Application Reference: 2025/0621

Site Address: 32 Park Avenue, Penistone, Sheffield, S36 6DN

Introduction: The application seeks full planning permission for the removal of existing single storey rear extension, and erection of 2 storey side and single storey front and new rear extensions to dwelling.

Drawing Title
Existing Floor Plans

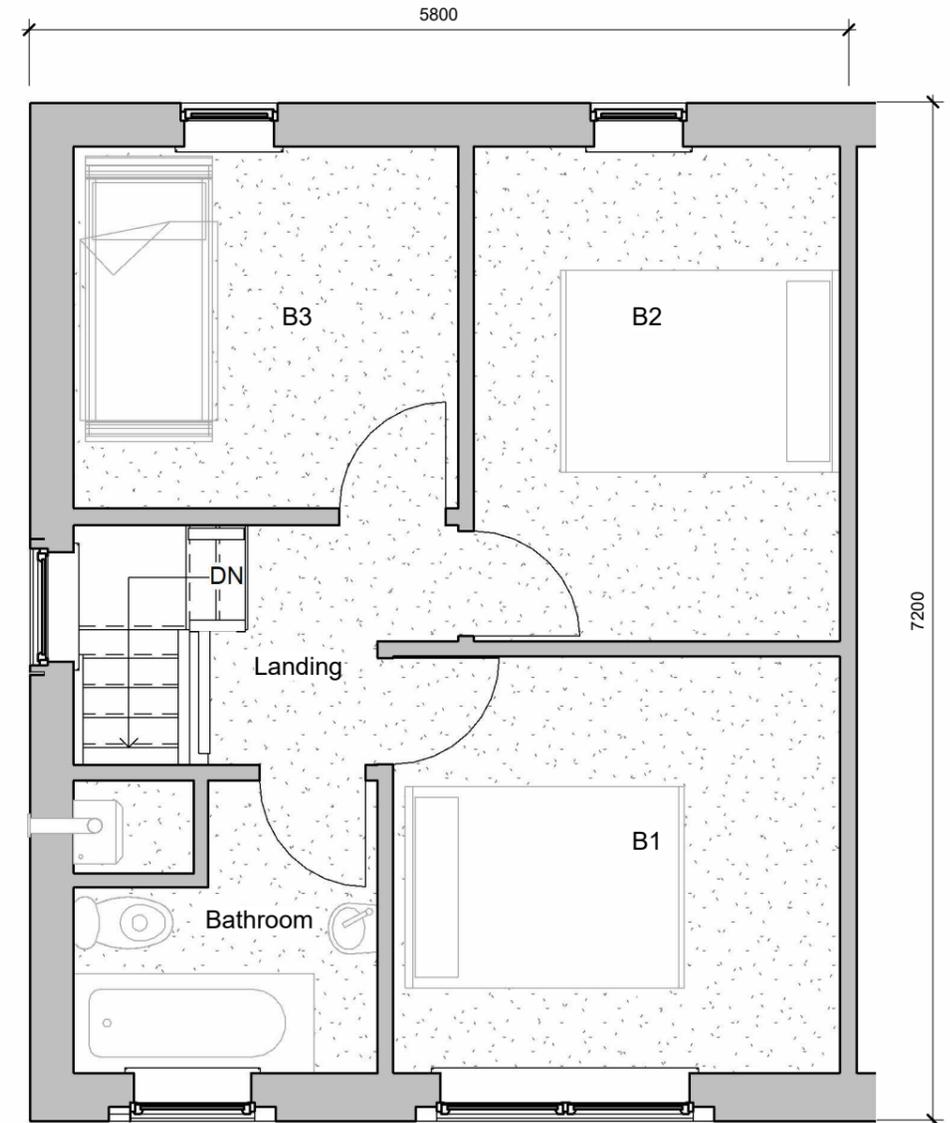
With a maximum side projection of 3.3m, the proposal is close to the maximum two thirds width of the original house, in this instance 3.66m, as outlined in SPD House Extension and Other Domestic Extensions. With a diagonal boundary treatment, the side projection does gradually reduce in width to 1.78m at the junction with the rear elevation and reduces further to 1.28m as it adjoins the rear extension and extends a further 1.6m beyond original rear elevation.

The ground floor rear aspect of the proposal extends or replaces an existing utility room, with an approximate increase in width of 2.37m, not including the attached aspect of the side extension. The rear projection remains at 2.05m. The ground floor front extension is a very modest aspect of the side extension which projects just 0.75m beyond the original front elevation of the dwelling, elevation whilst extending the side projection by 0.34m. Together this aspect of the proposal represents an approximate 2.75 sqm of extension beyond the front elevation of the dwelling. For square metreage comparison only, a porch is allowed a footprint of up to 3sqm.

Drawing Title
Proposed Elevations

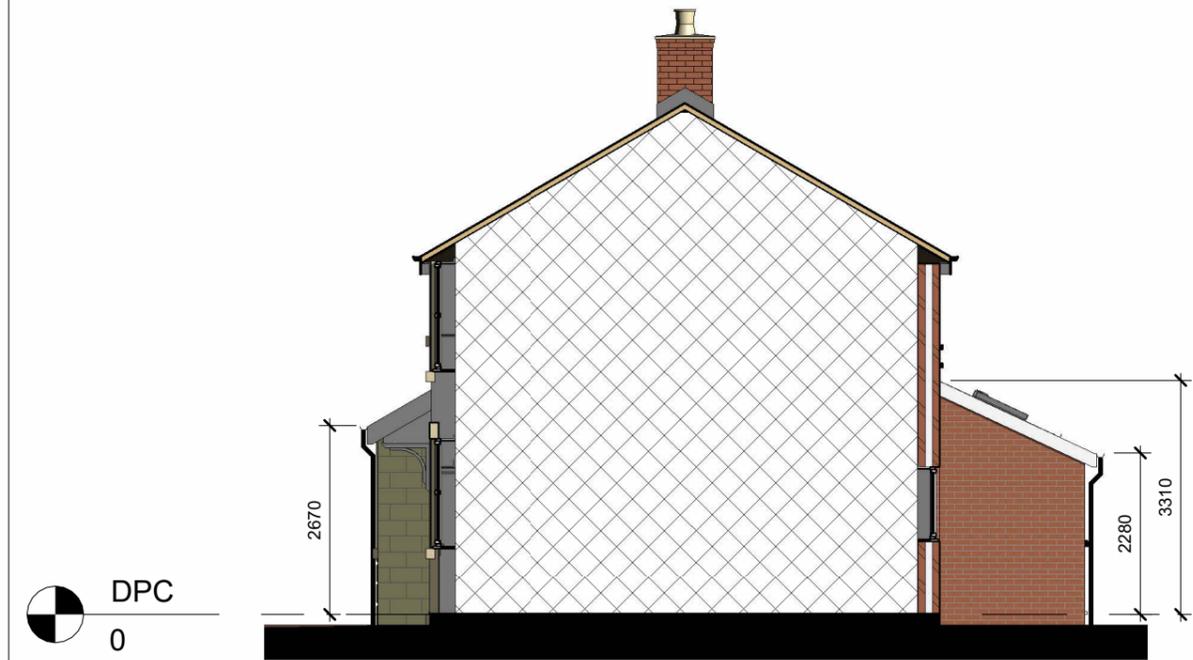
Initially the proposed roof was ultimately deemed not to be in accordance with the House Extensions and Other Domestic Alterations SPD, which requires a step down of the roof to show subordination to the host dwelling. Following a request for amended plans, the proposed new roof is not only in accordance with the SPD but is also more sympathetic with the original

As noted above the extension is constructed almost entirely up to the boundary, which goes against the guidance of the SPD House Extension and Other Domestic Alterations, which to avoid the terracing effect, suggests a gap of 1m should be maintained between a side extension and a boundary. In mitigation, in addition to the single storey garage located between the dwellings, the neighbouring dwelling is also set at an approximate 50-degree angle, facing away from the application dwelling. Therefore, even with the extension being up to the boundary, no terracing effect would be created.

character of the dwelling and broader street scene, with a similar step down of roof to that of the opposite dwelling of No.17.

- The originally proposed roof was not considered in accordance with the SPD House Extensions and Other Domestic Alterations. Amended plans were requested and submitted, which successfully fulfilled the criteria.
